LISTED BUILDING CONSENT

Application Reference: DC/22/06263

Application for Listed Building Consent - Erection of single storey side extension (following removal of existing structure).

Bressummer Cottage, Poy Street Green, Rattlesden, Bury St Edmunds Suffolk IP30 0SR

PLANNING CONDITION 9

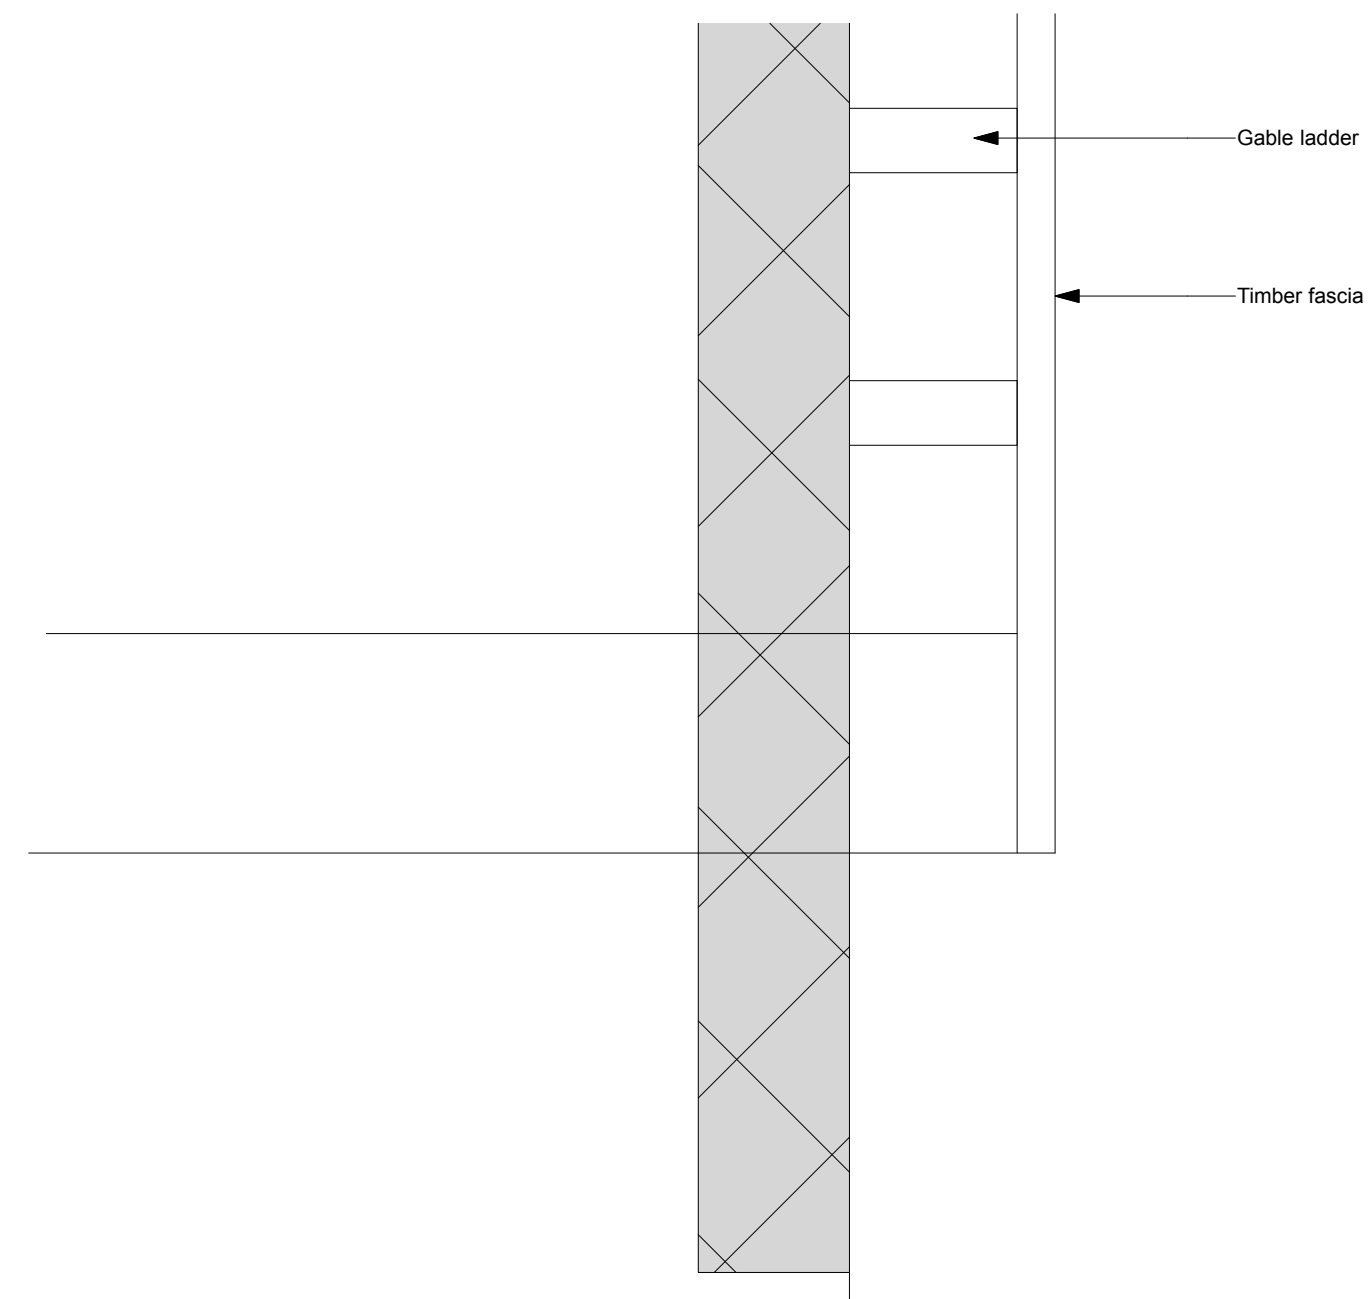
Prior to the commencement of works above eaves level, detailed section drawings through the proposed eaves and verges of the extension, to cover the main roof and catslide, at 1:20 or as appropriate, shall be submitted to and approved in writing by the Local Planning Authority.

PLANNING CONDITION 10

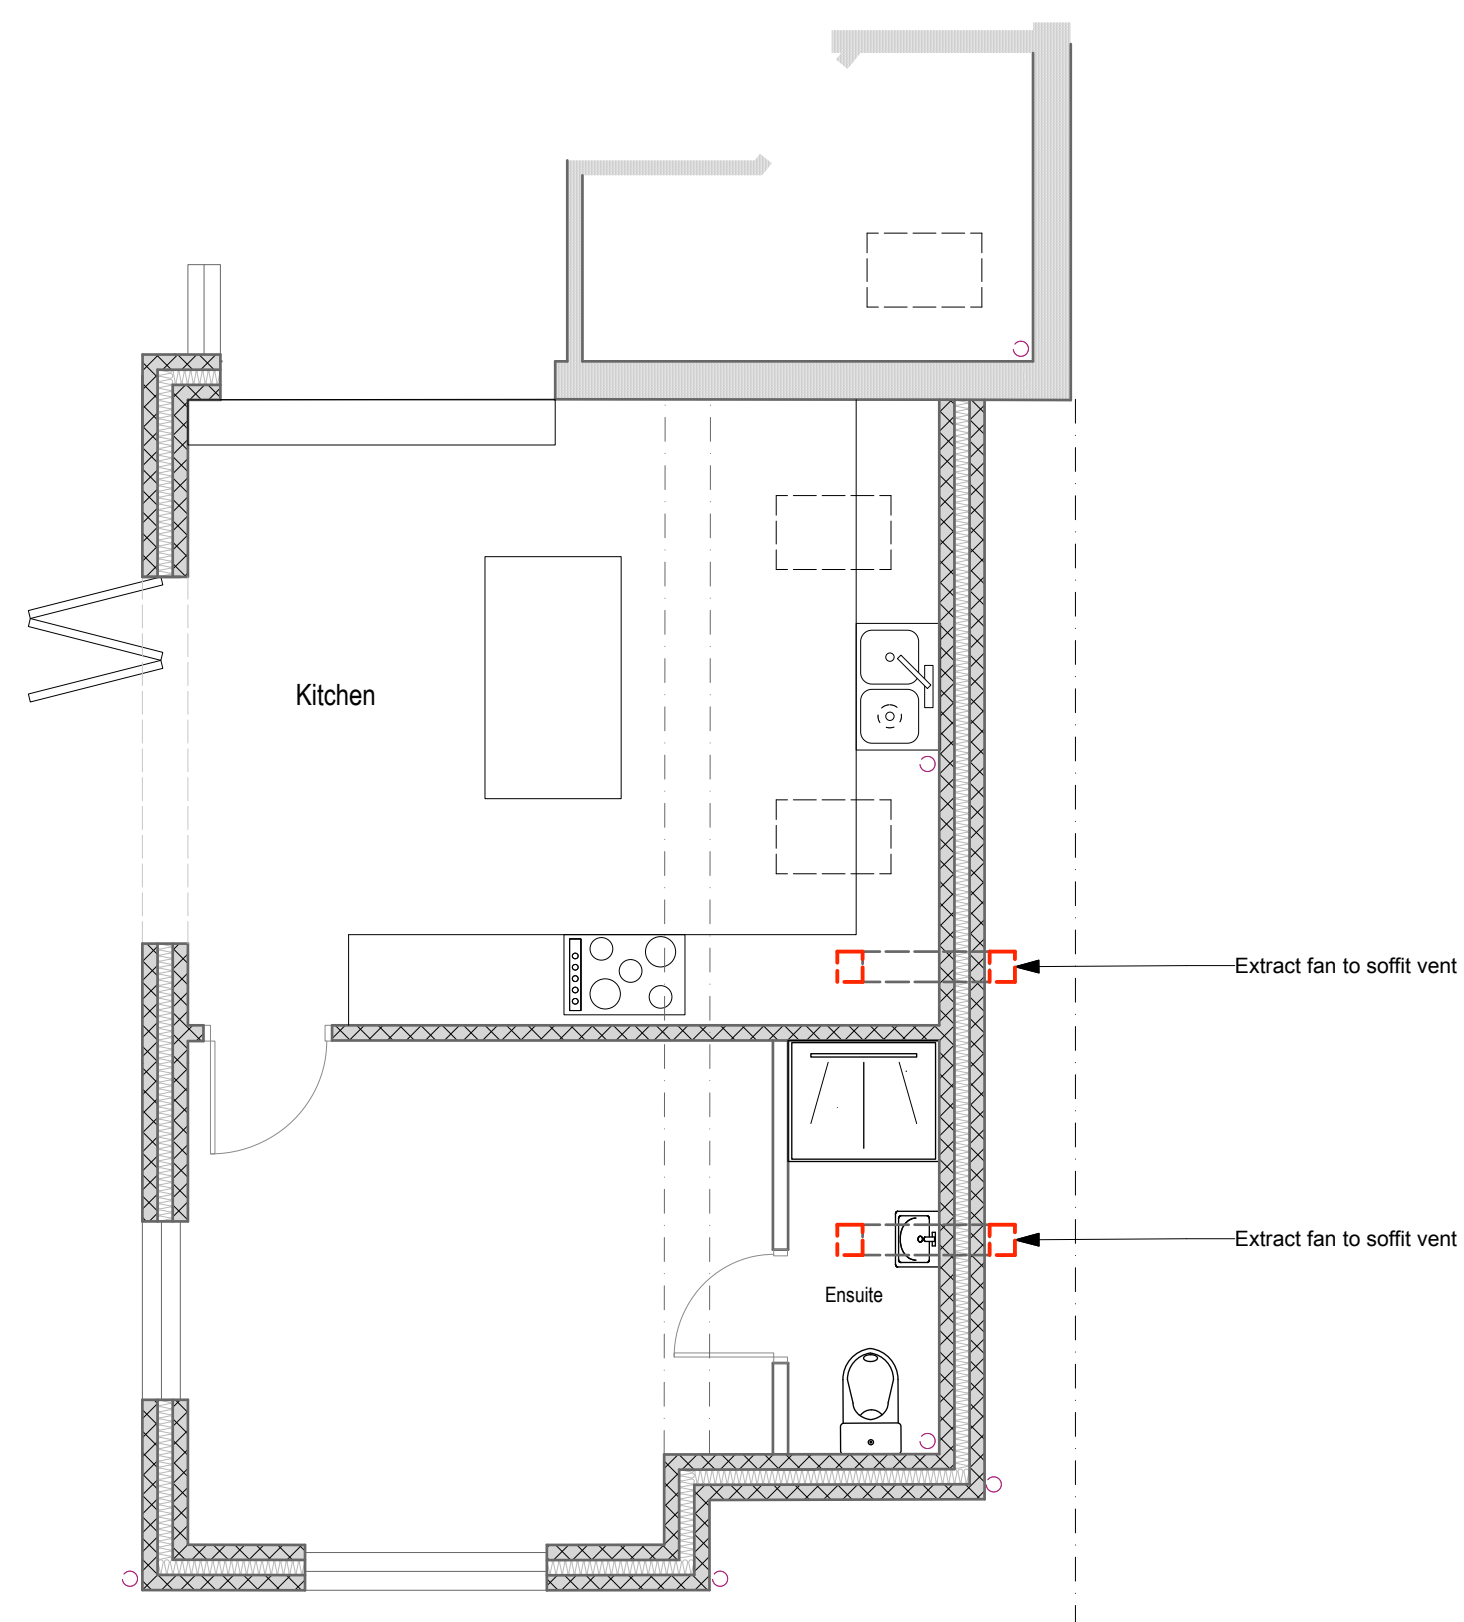
Prior to the installation of new rainwater goods, manufacturer's details of proposed rainwater goods, shall be submitted to and approved in writing by the Local Planning Authority.

PLANNING CONDITION 8

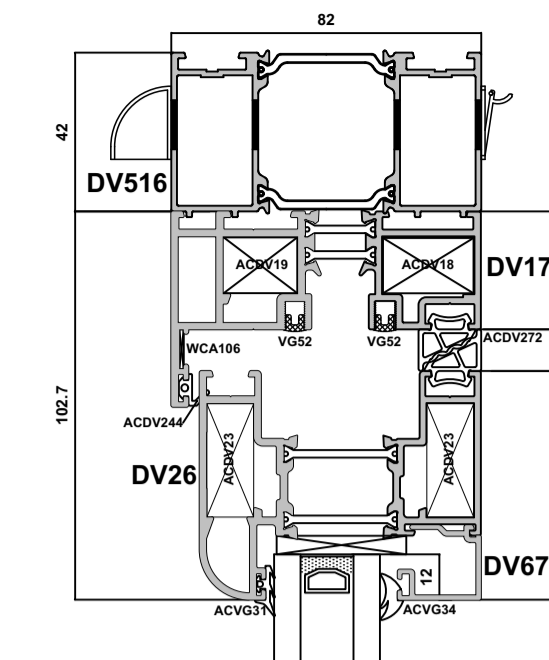
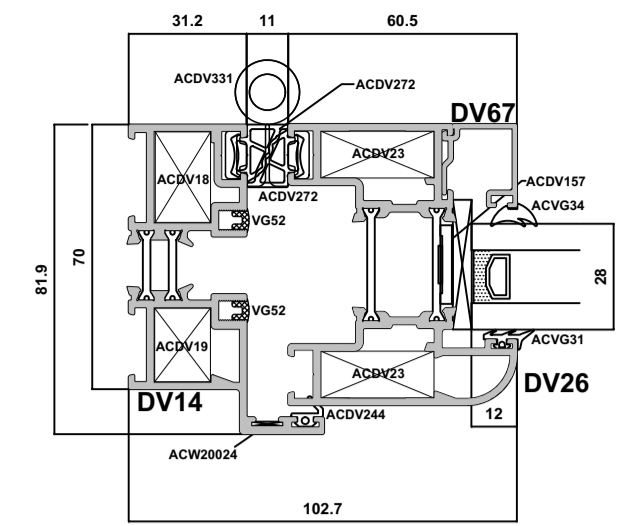
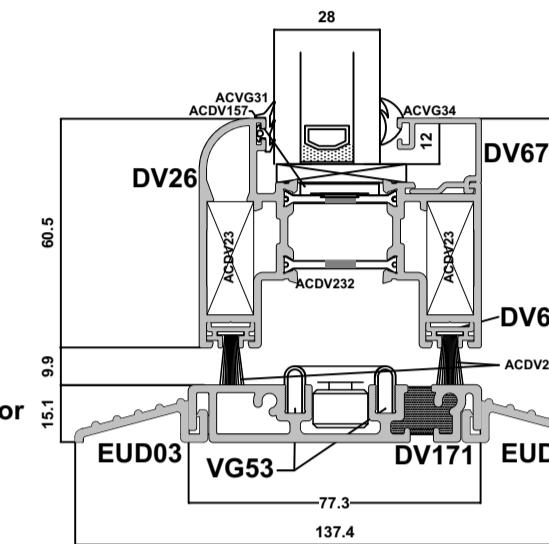
Prior to the installation of new rooflights, manufacturer's details of proposed rooflights, shall be submitted to and approved in writing by the Local Planning Authority.

PLANNING CONDITION 7

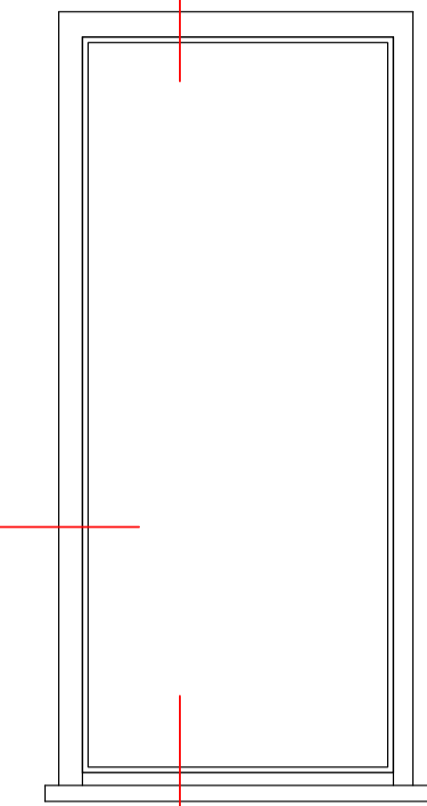
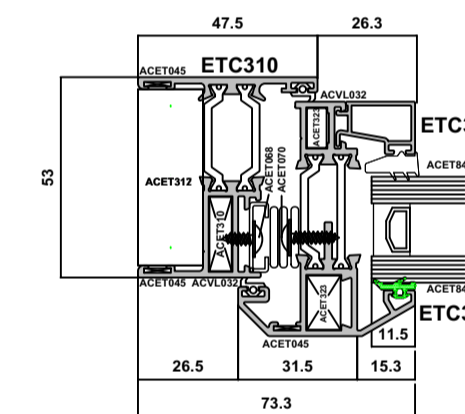
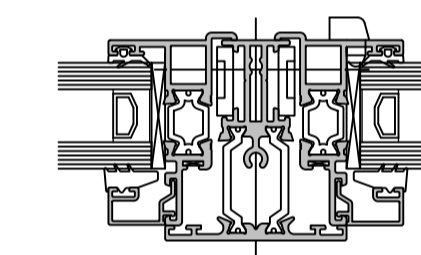
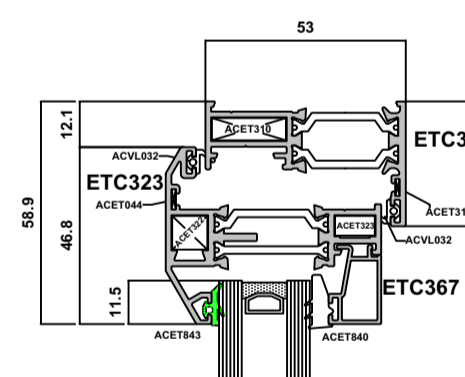
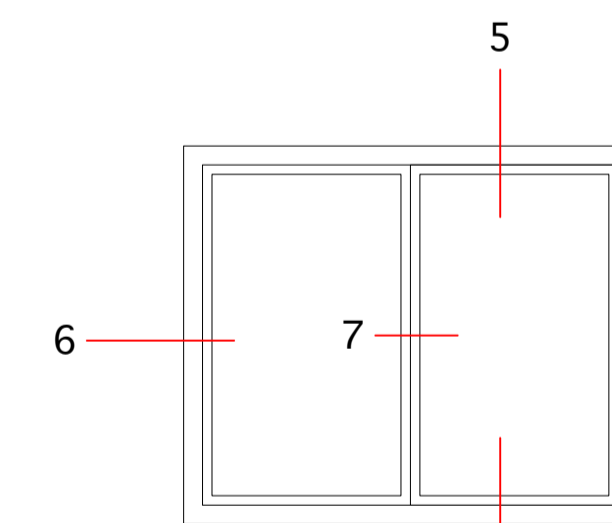
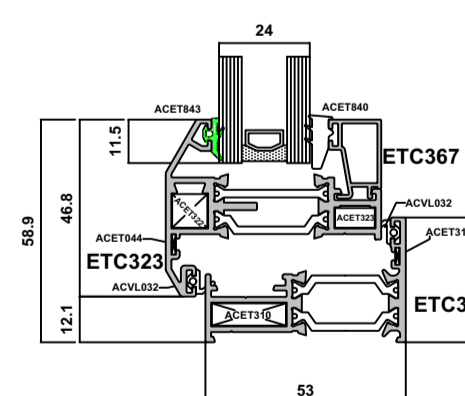
Prior to the installation of new windows and doors, details of proposed windows and doors, to include manufacturer's literature and/or elevation and section detail drawings at 1:10 and 1:2 respectively, or as appropriate, shall be submitted to and approved in writing by the Local Planning Authority.
